Charlotte Department of Transportation

Memorandum

Subject: Rezoning Petition 08-073: Located on both sides of Statesville Avenue
between Newland Road and Woodward
Avenue

Petition #: **2008-073**

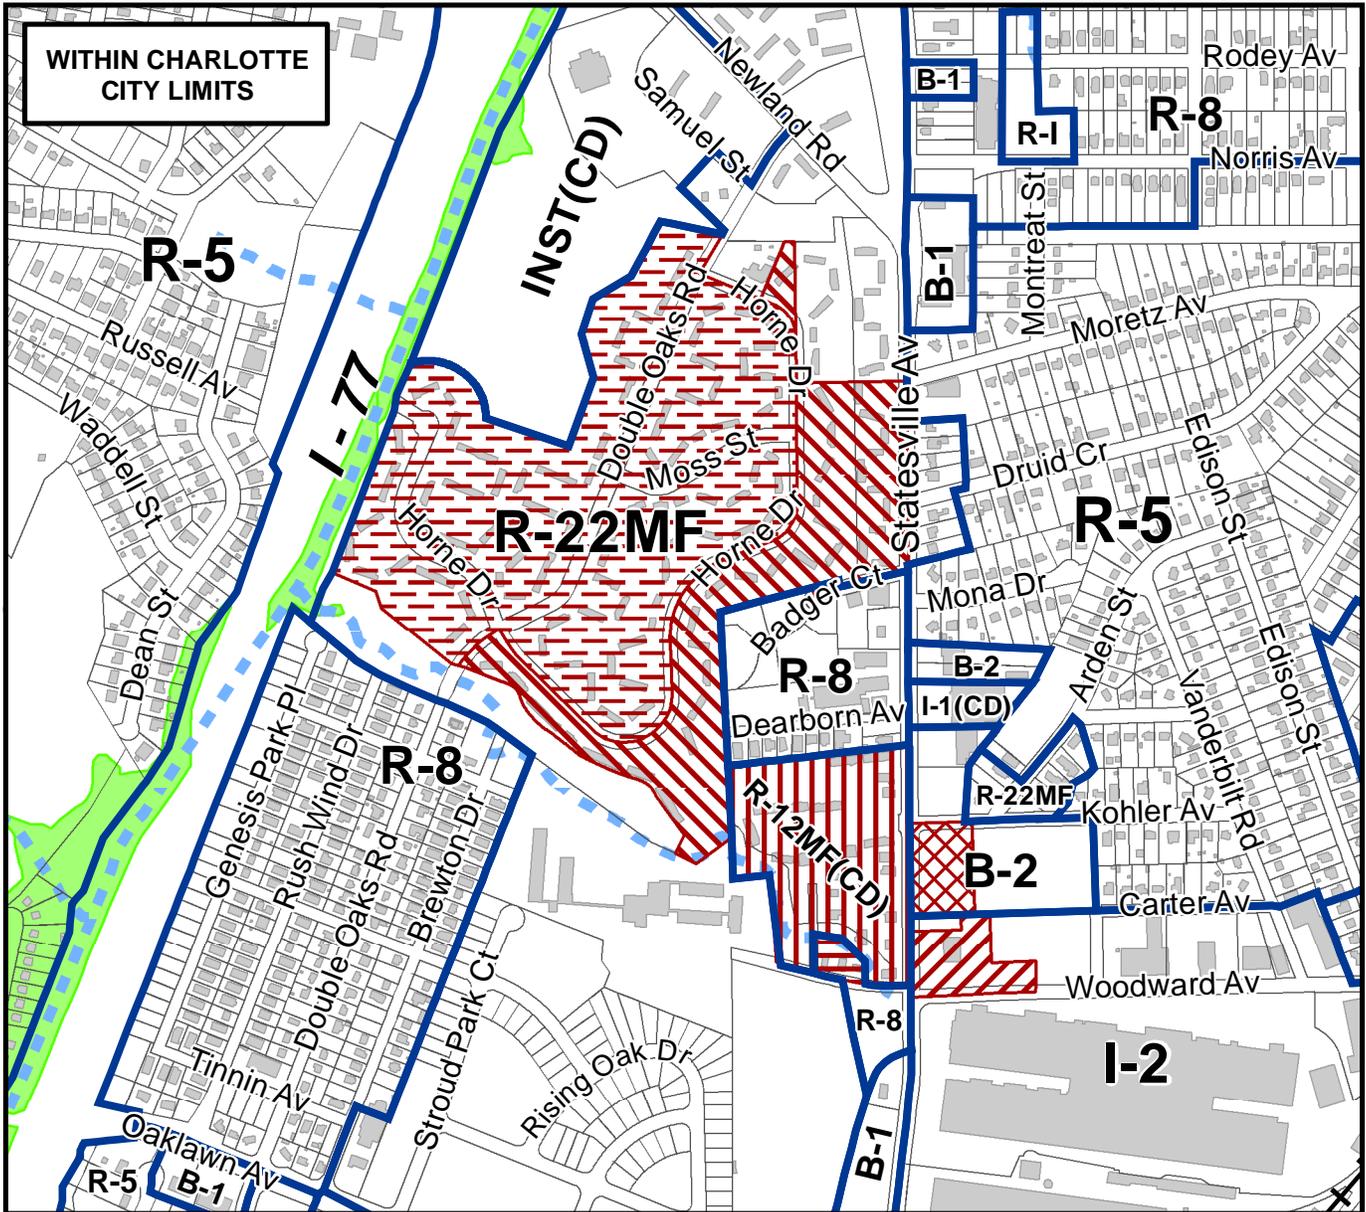
4. It appears from the rezoning plan that only half of some streets are included in this petition. The map needs to be revised to include entire street widths, specifically, Street "F" and Street "J".

SP101

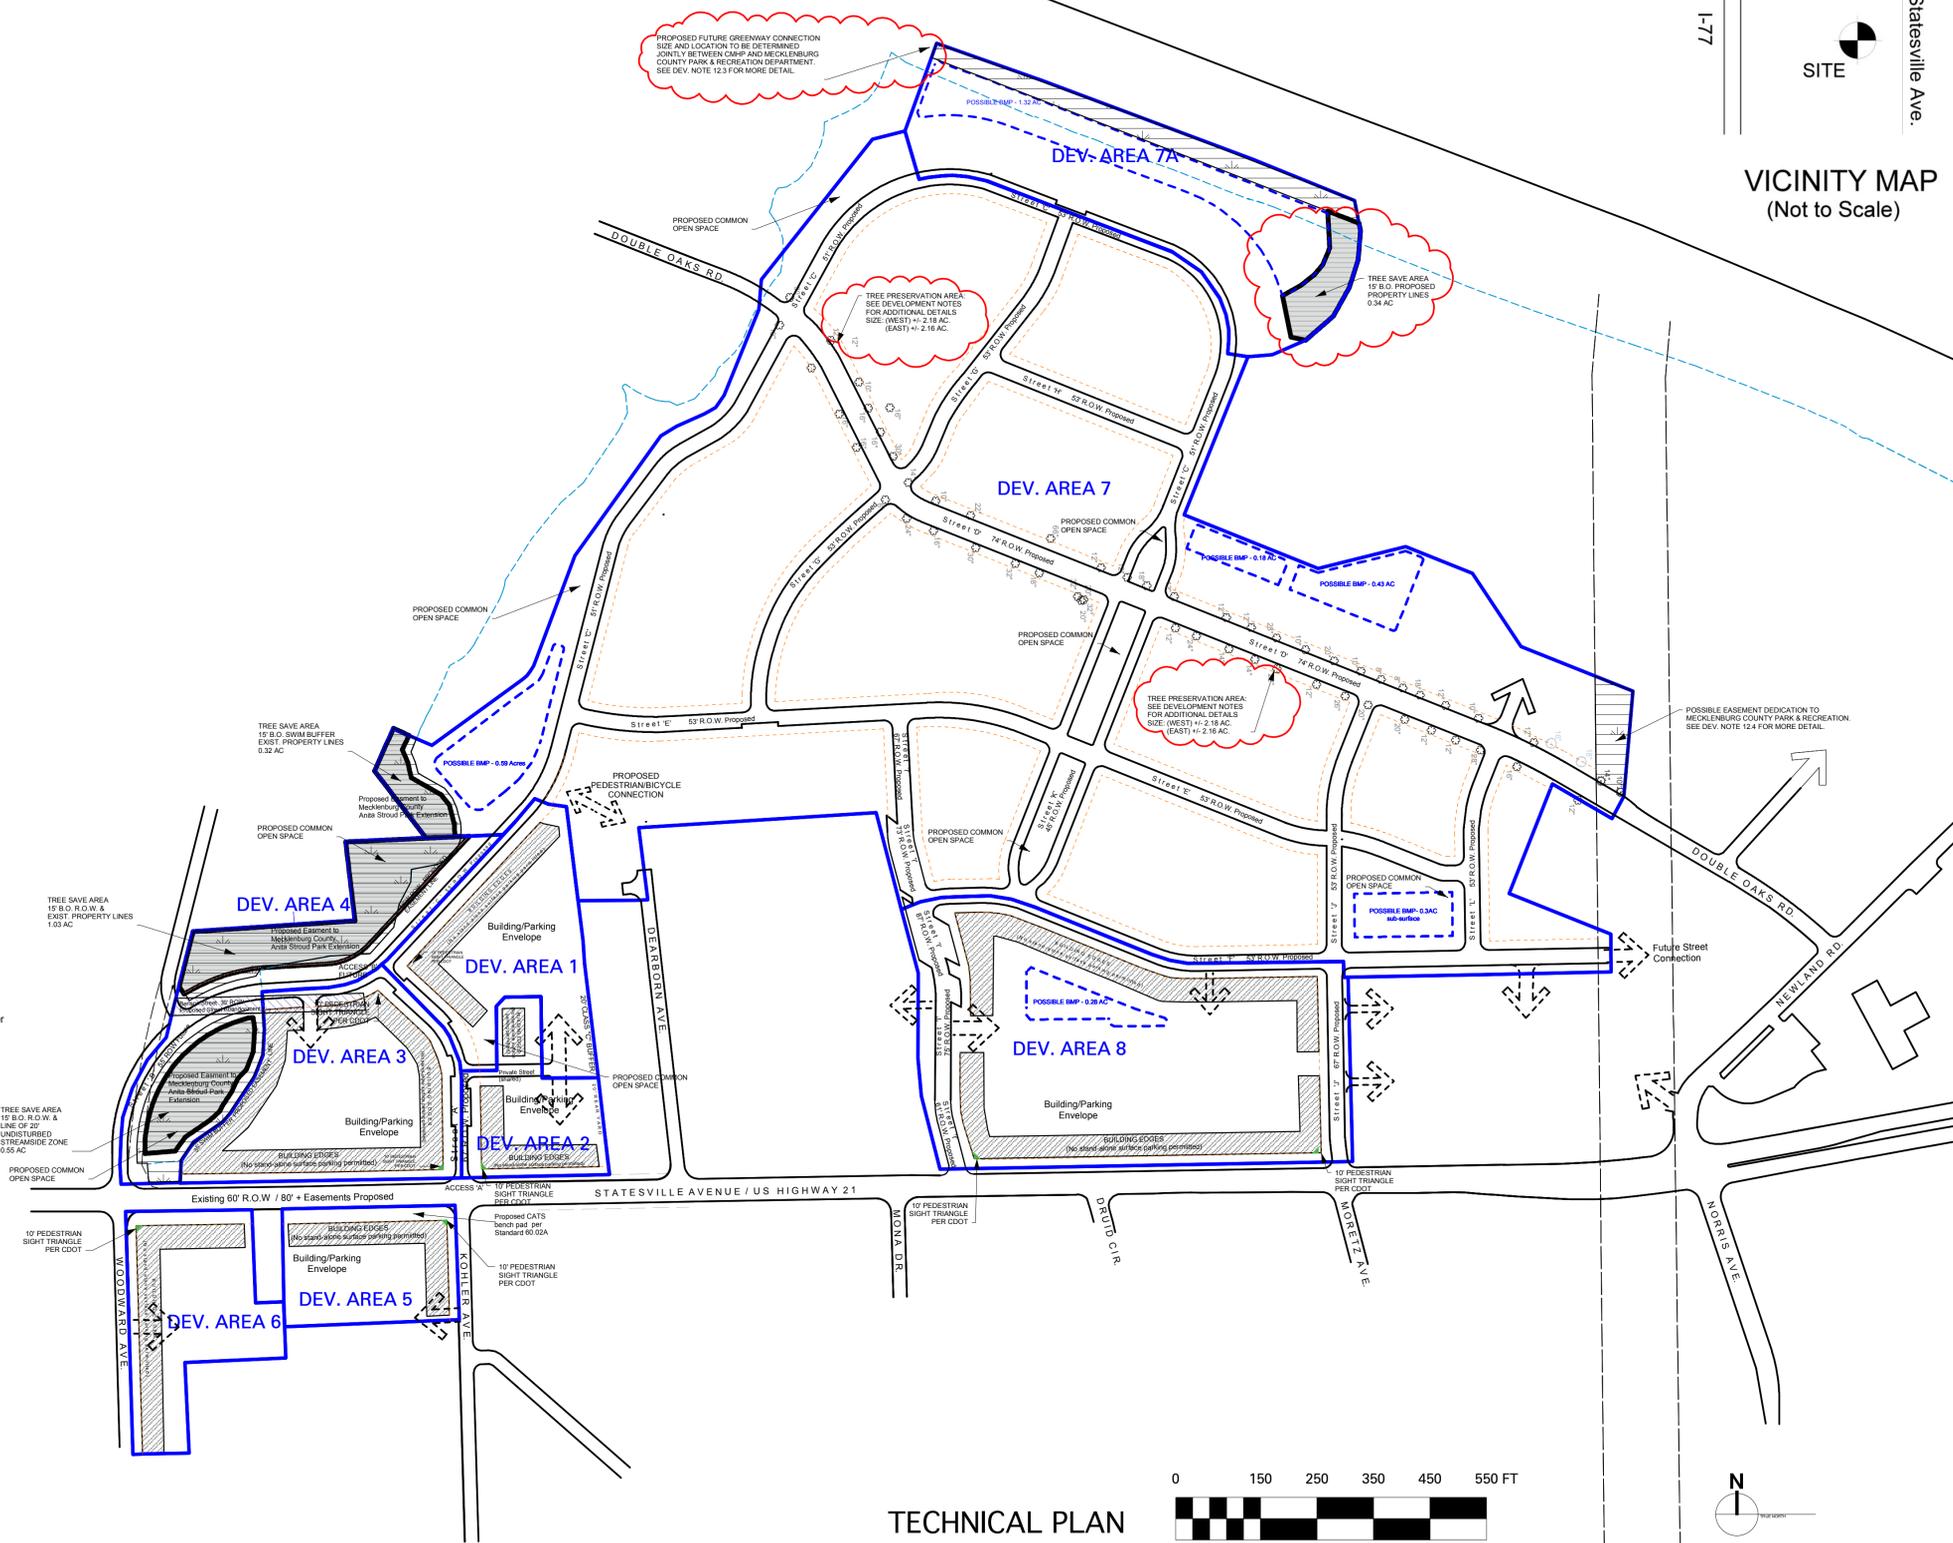
3. Roundabouts are typically used in lieu of standard intersections under some circumstances to more efficiently assign right-of-way for vehicles, maintain reasonable vehicle speeds, and better accommodate pedestrian movements. The roundabout in its current location does not seem to be necessary. Design of the roundabout will be reviewed in subsequent permitting phases. It should be noted that parking, whether or not it is recessed, will not be permitted within the roundabout. Additionally, on-street parking on the streets intersecting the roundabout will not be permitted at locations that will result in conflicts between vehicles entering/exiting the roundabout and those maneuvering to/from parking spaces.

5. The site connects to an existing right-of-way at Dearborn Avenue. Dearborn Avenue needs to be extended through the site to meet the block spacing requirements of the USDG.

8. The northern end of the proposed median on Street D needs to appropriately transition to the non-median divided street cross section of existing Double Oaks Drive. The median transition is conceptually shown correctly at the southern end of the cross section as it connects with the existing section of Double Oaks Drive.

9. Street D and Street G need to intersect at 90° in order to provide a more urban designed intersection. The proposed skew of the intersection needs to be eliminated in order to keep

pedestrian crossing widths as short/compact as possible and corner radii consistent/adequate for typical design vehicles, particularly at median divided streets (Street D).

10. The site plan shows a private driveway access at the end of Street F. Public streets are not permitted to end as driveways into private developments. Driveways must be located at 90° to a public street. If the street is intended to be extended and connect in the future with Double Oaks Drive opposite Samuel Street, then the private access “arrow” needs to be deleted/modified to indicate a future street extension rather than a private driveway.
11. As indicated in the rezoning of the previous phase of the Double Oaks Development, the NCDOT will require a median on Statesville Road along the site’s frontage. The same cross section needs to be shown on this site plan.
12. Please provide a scale for sheets SP 101 and SP 102.
13. Additional comments and any required transportation improvements will follow our review of the TIS.

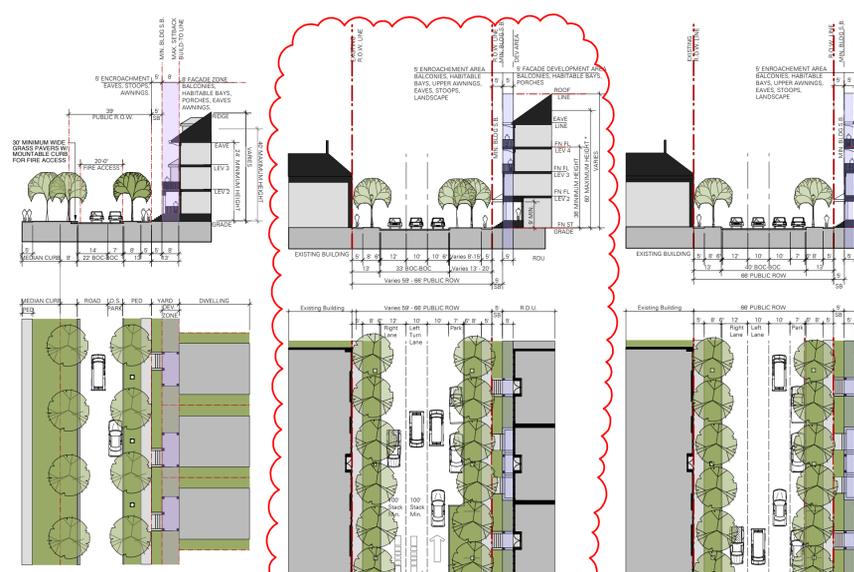
6. As proposed, several streets have substandard widths. All proposed streets need to be of sufficient width to facilitate multiple modes/types of vehicles and meet the USDG. For example, Street K/Street Section 4 shows a travel lane that is too narrow next to a median and on-street parking. Fire code requirements may also not be met with this design. Additionally, the park/median of Street K needs to transition to the typical street section for Street C in advance of Double Oaks Drive for lanes/movements to properly align. This transition is also needed prior to its intersection with Street F. Although these items will be reviewed during subsequent review processes, since reconfiguration is necessary, this needs to be revised on the site plan.

7. Street K is a proposed park/median divided street. However, the right-of-way shown for its one-way street cross section is only 45 feet. The right-of-way for Street K needs to include both one-way street cross sections and the park/median.
